First floor extension above lower roof of existing dwelling to form 2 bedrooms.
2 West Close Middleton on Sea

Thank you for your internet representation made on 28th December 2011 which has been recorded as **an objection** with the comments as follows:

Proposed First Floor Plan

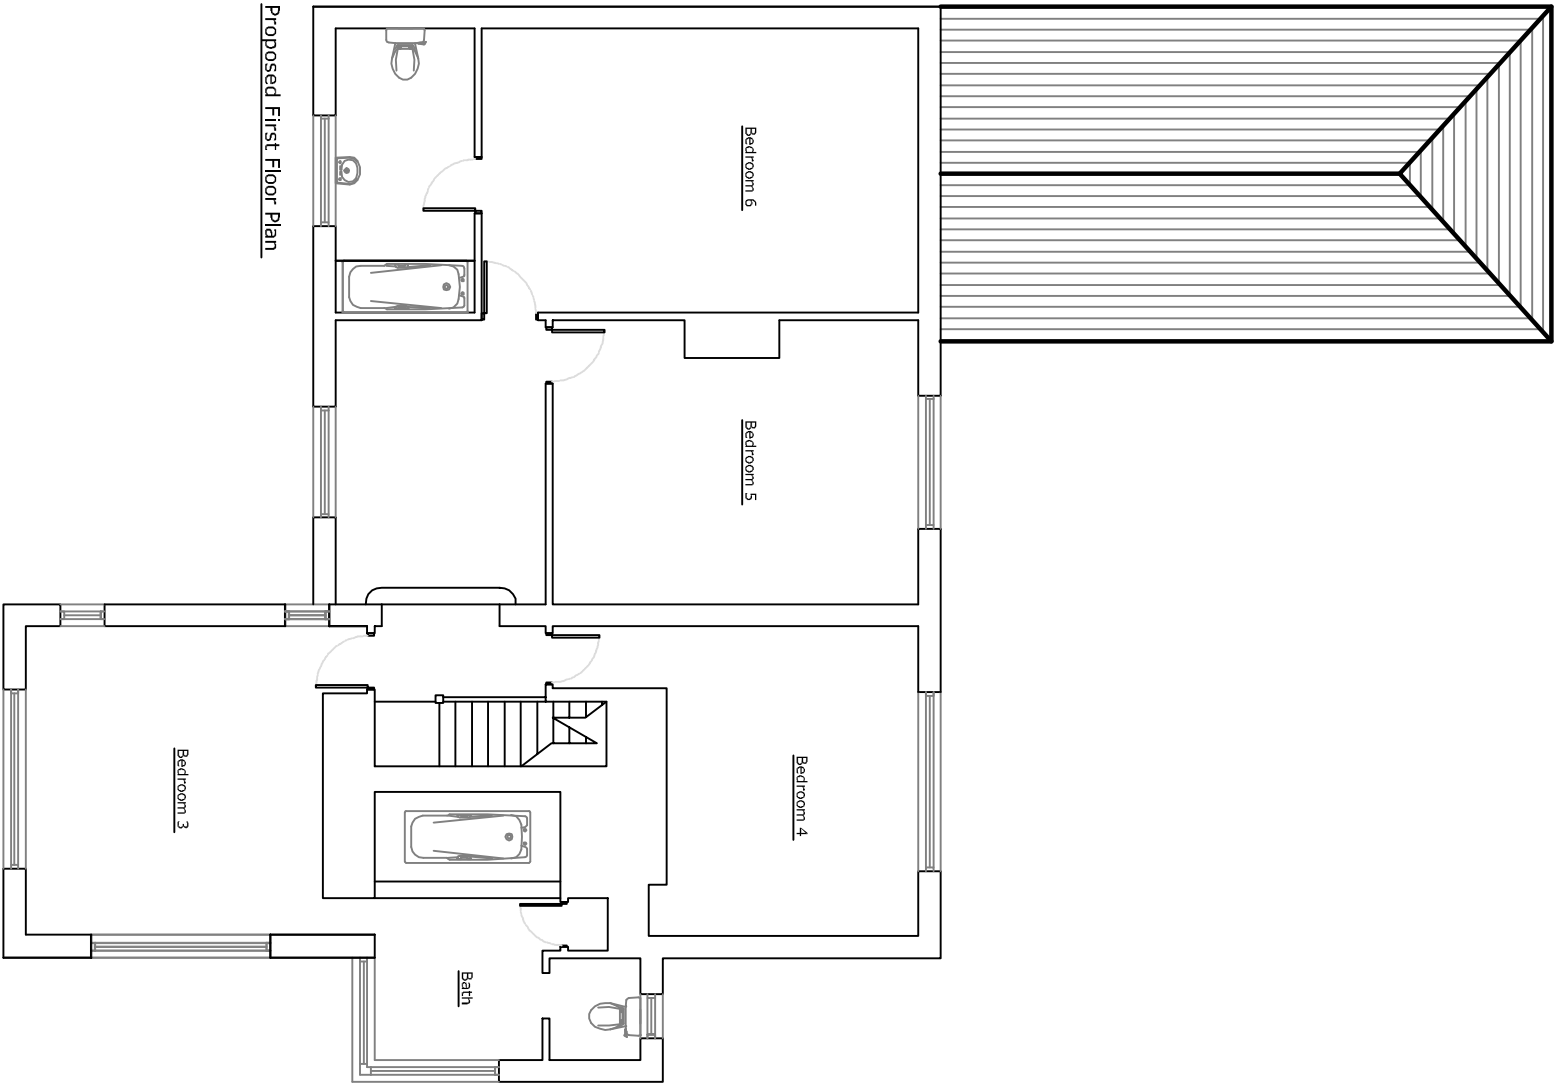
*□
Secondly, we have reviewed the original plans and these do not allow sufficient headroom to pass between bedroom 6 and the ensuite bathroom proposed and therefore will not satisfy building regulations. We ask that the technical feasibility of the original plans be investigated. Both original and substitute plans reaffirm our concern that the side roof construction, if plans are approved, will be built significantly higher than the plans, further limiting the light and amenities of the adjoining property and raising concerns of compliance for Building Control.*

RECEIVED
20.12.11
20.12.11

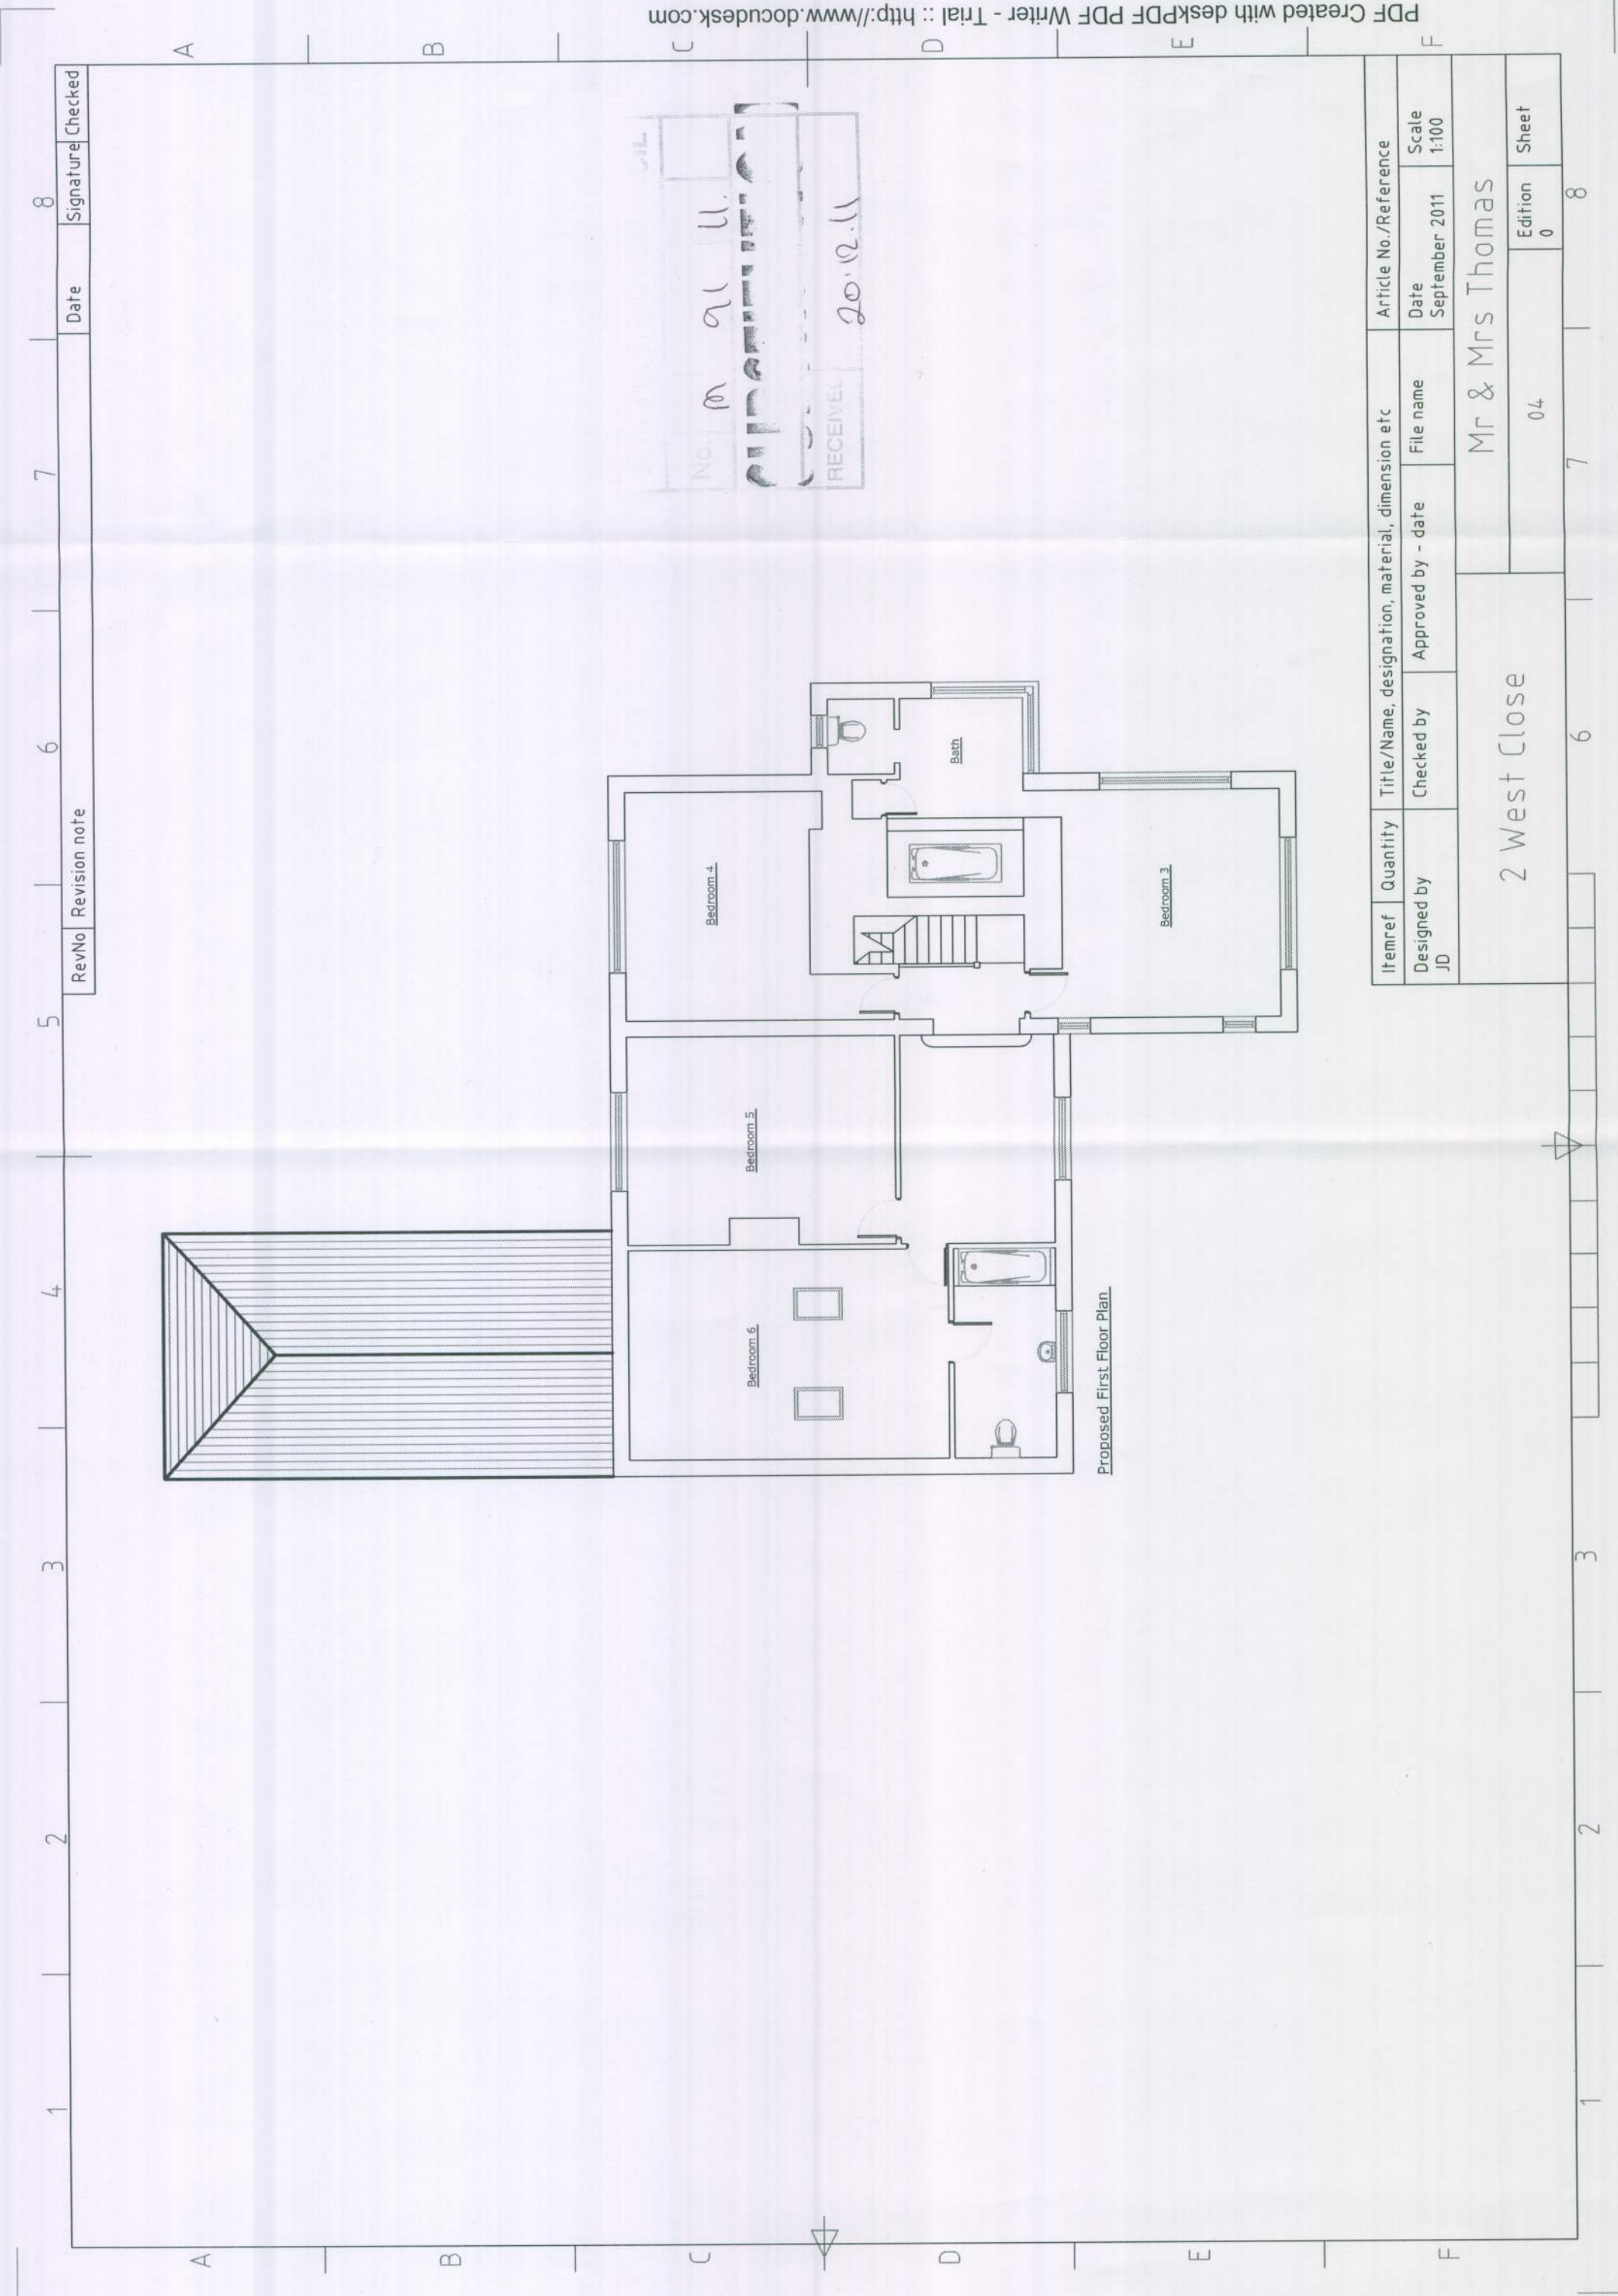
Further to our earlier submission, we wish to make two comments of objection on the plans and the replacement floor plan submitted on 20 December 2011. We note the latter includes roof lights to the proposed bedroom 6 which will look on to one bedroom of our property, 1 West Close. The proposed building will limit the light to two bedrooms: one in the original two storey building (visible from the rear elevation) and one in the extension completed in 2006 (side elevation) and the placement of the proposed roof light/windows will look into the bedroom of the original two storey building. We refer you to the original planning approval of M/68/87 that placed a condition of no further windows or other openings in the single storey extension of 2 West Close "to protect the amenities of the adjoining residential property". This condition is even more relevant now given the location of the proposed second floor extension and its proximity to our property. □
